**From:** Olson, Greg  
**Sent:** Thursday, March 06, 2014 1:06 PM  
**To:** 'David Soule'; 'Carlos Spiess'  
**Cc:** 'Jerry'; Rodriguez, Jason T.; Olson, Greg  
**Subject:** RE: L23-D022 Beehive Homes - SO-19 Connection to the 4-Hill Channel  
**Attachments:** Section A-A notes on 10-4-13 plan.pdf; L23D022\_Aproved\_GandD\_2013OCT04seal-small.pdf; L23D022\_revisedLTRapproved\_GPforGP-BP-SO19\_BeehiveHomes\_10-04-2013 Seal.pdf; L23-F022\_FLOODPLAIN PERMIT for Channel Connection.pdf

The "Approved Plan" is the Grading Plan sheets that you prepared and we approved (10-4-13 Seal), with the connection details at the channel.

One exception is the corrections I requested on Section A-A, Sheet 2, which I forwarded to you on 10-9-13, clarifying

SECTION A-A
NTS

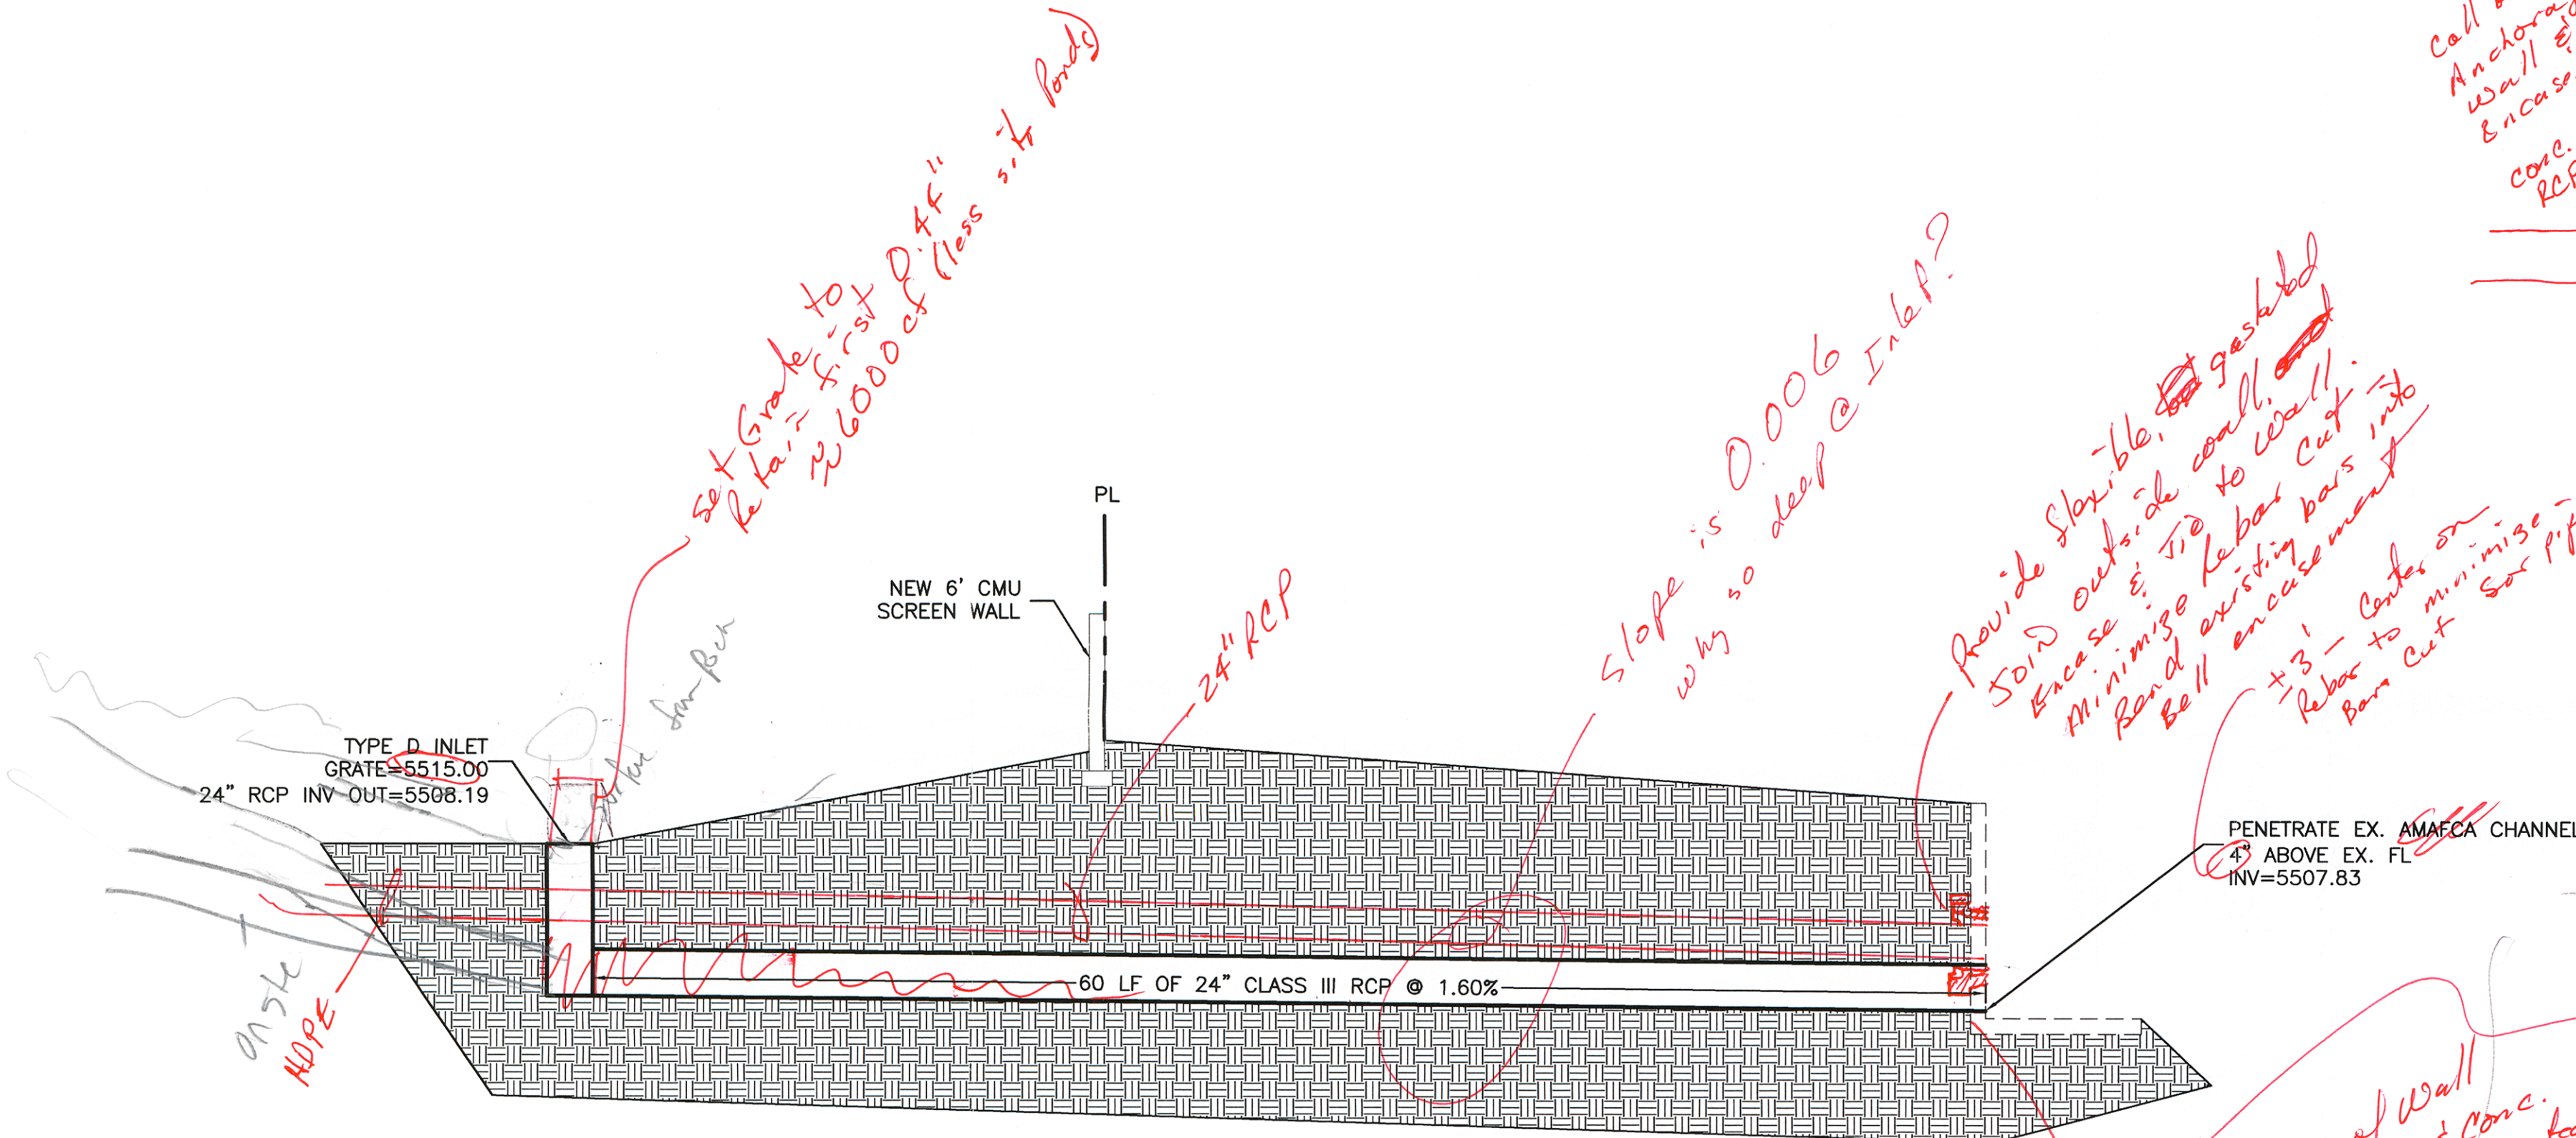
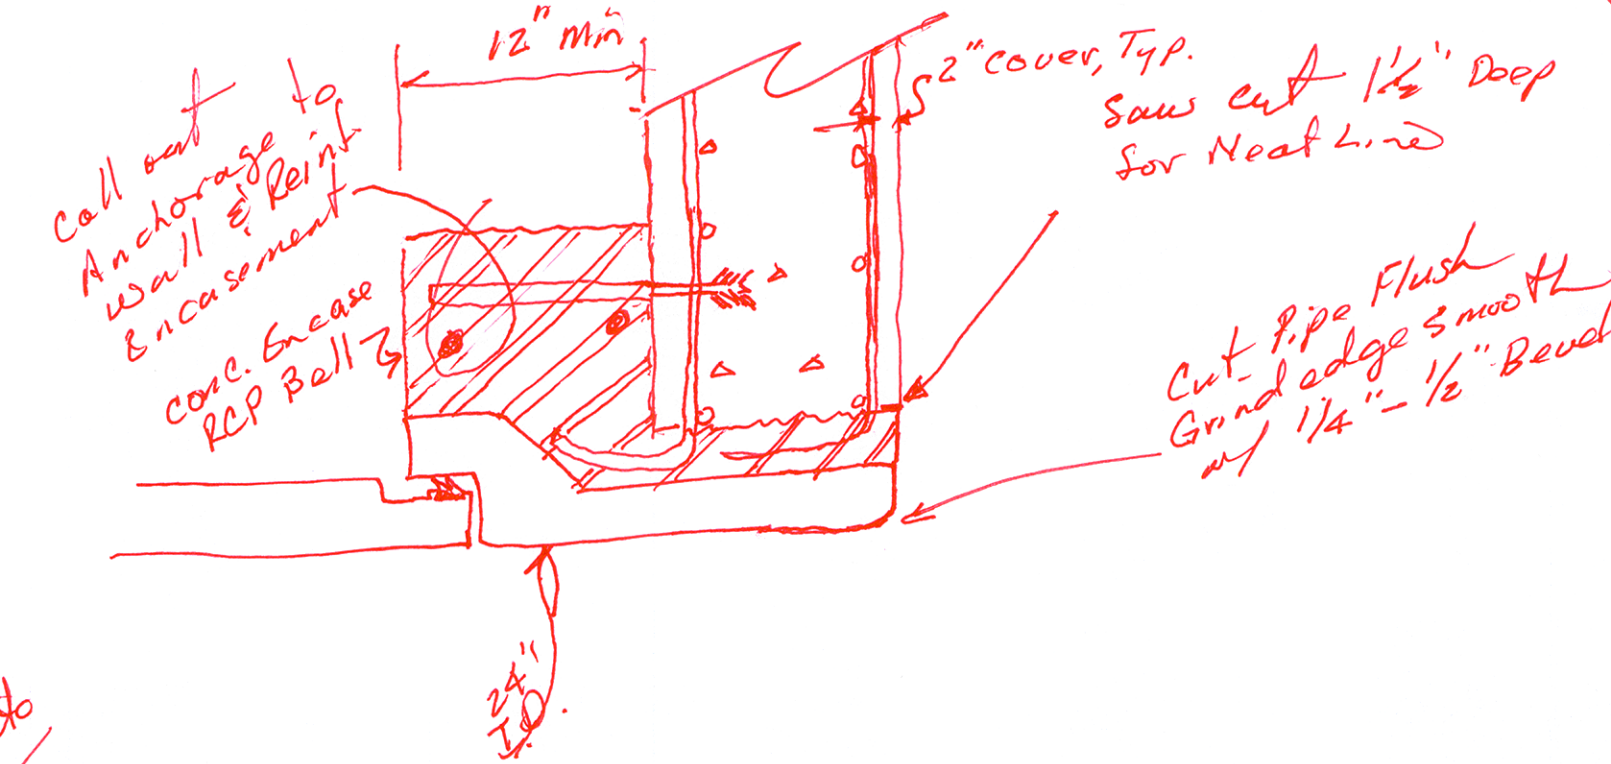
1. that Concrete (not Lean Fill) is to be used on the Bell Encasement, and
2. that 2-hoops of #4 rebar should be added to the Bell Collar, outside the channel wall.
3. I am attaching that mark-up for use in the field, in case you did not get the Permit set corrected.
